## Appeal Decision

### Appeal Ref: 6005232

#### 10 Sipson Lane, Hayes, Hillingdon UB3 5EH

- The appeal is made under section 78 of the Town and Country Planning Act 1990 (as amended) against a refusal to grant planning permission.
  - The appeal is made by Mr Paramjit Singh against the decision of the Council of the London Borough of Hillingdon.
  - The application Ref is 23513/APP/2025/2365.
  - The development proposed is a hip to gable loft conversion with a rear facing dormer.
-

Proposed Elevations

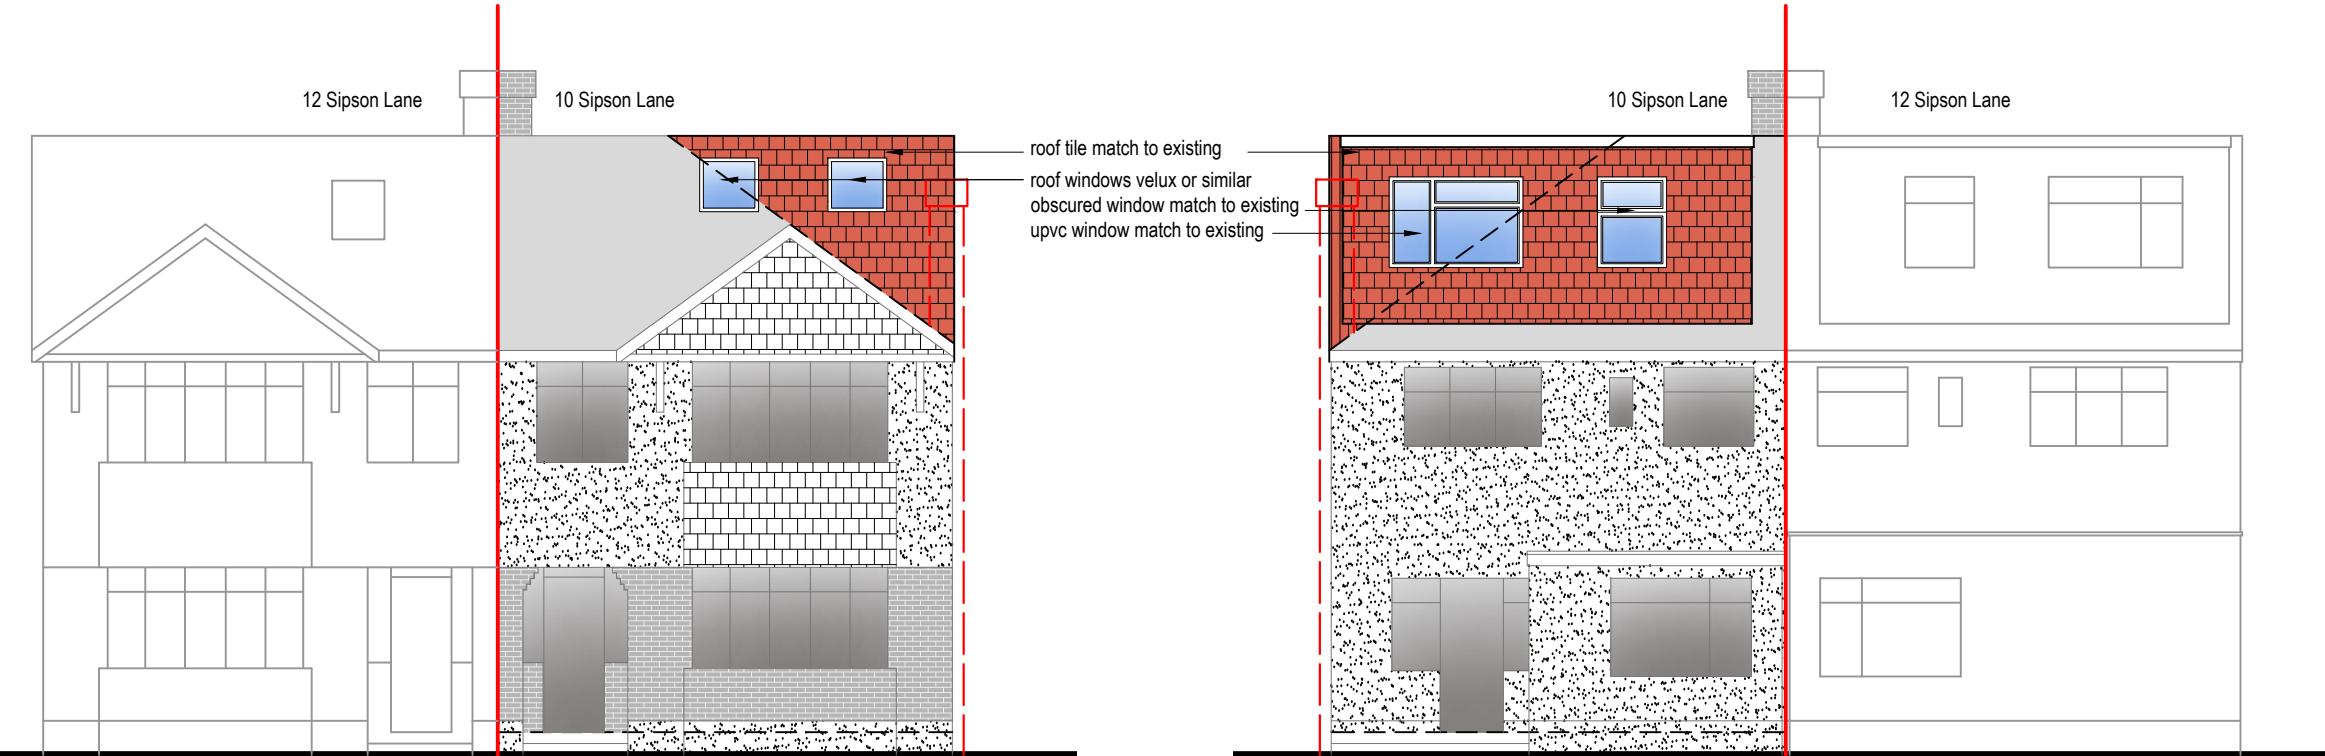
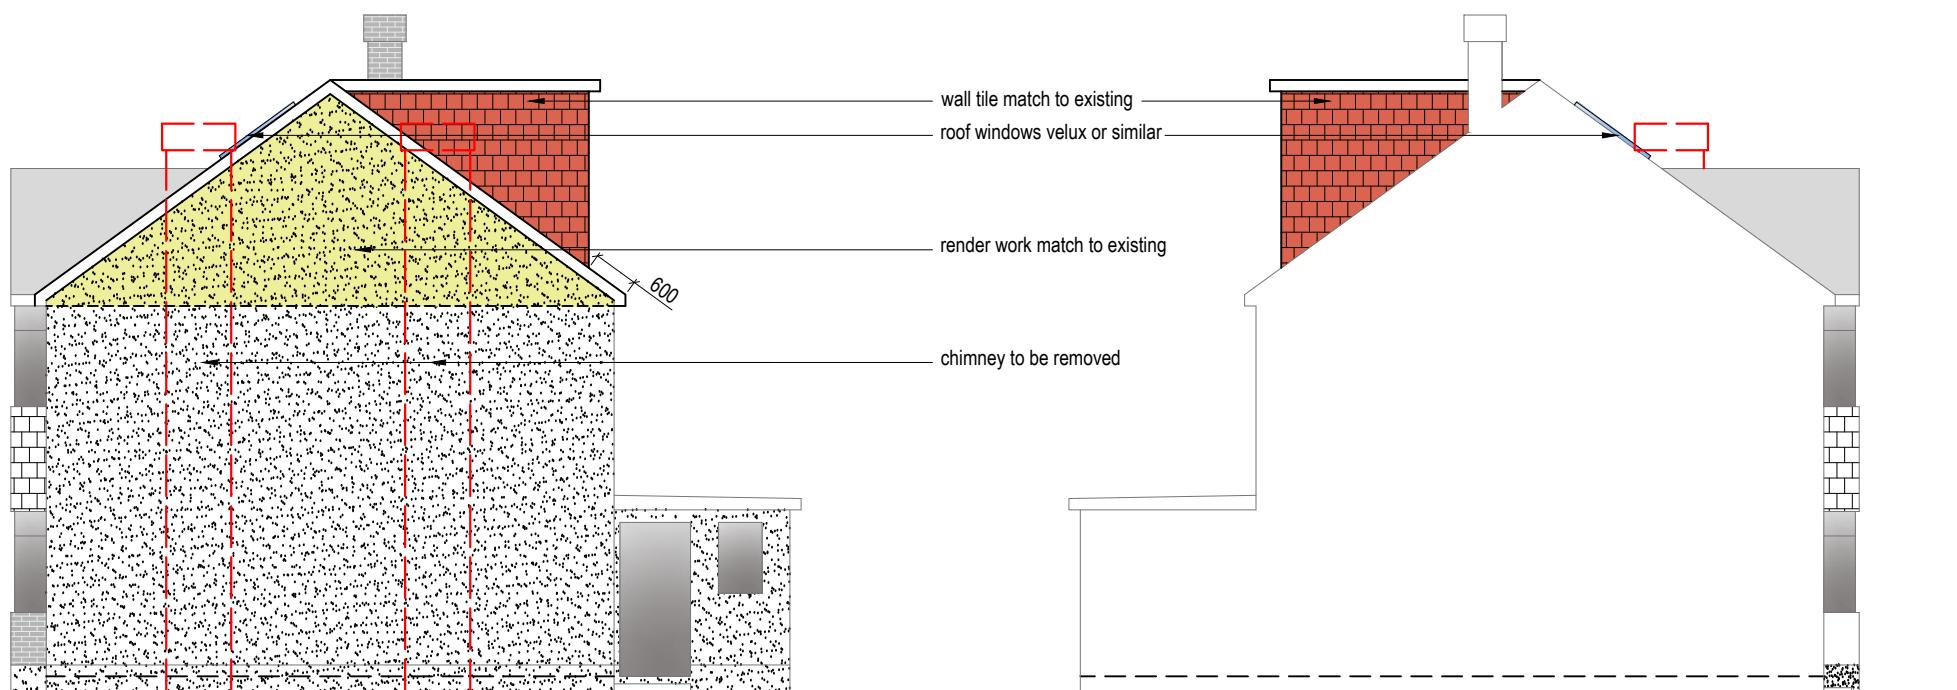
6. The proposed rear dormer would extend across almost the entire width of the extended roof plane and would rise to the main ridge height. In view of this excessive scale and bulk, particularly when viewed in conjunction with the massing

- of the proposed hip-to-gable extension, the proposed scheme would not appear subservient to the host dwelling. Instead, it would be a disproportionate, top-heavy addition that would unacceptably harm the architectural balance of the original house.

7. Furthermore, the proposed hip to gable roof extension would necessitate the removal of two side chimneys. These chimneys are a characteristic feature of homes in the line of properties on this part of Sipson Lane. Although I recognise that some chimneys have already been removed, many remain and these are integral to the character of the host building. Their removal, combined with the overall works to the roof profile, would result in the unacceptable loss of the original roof form.
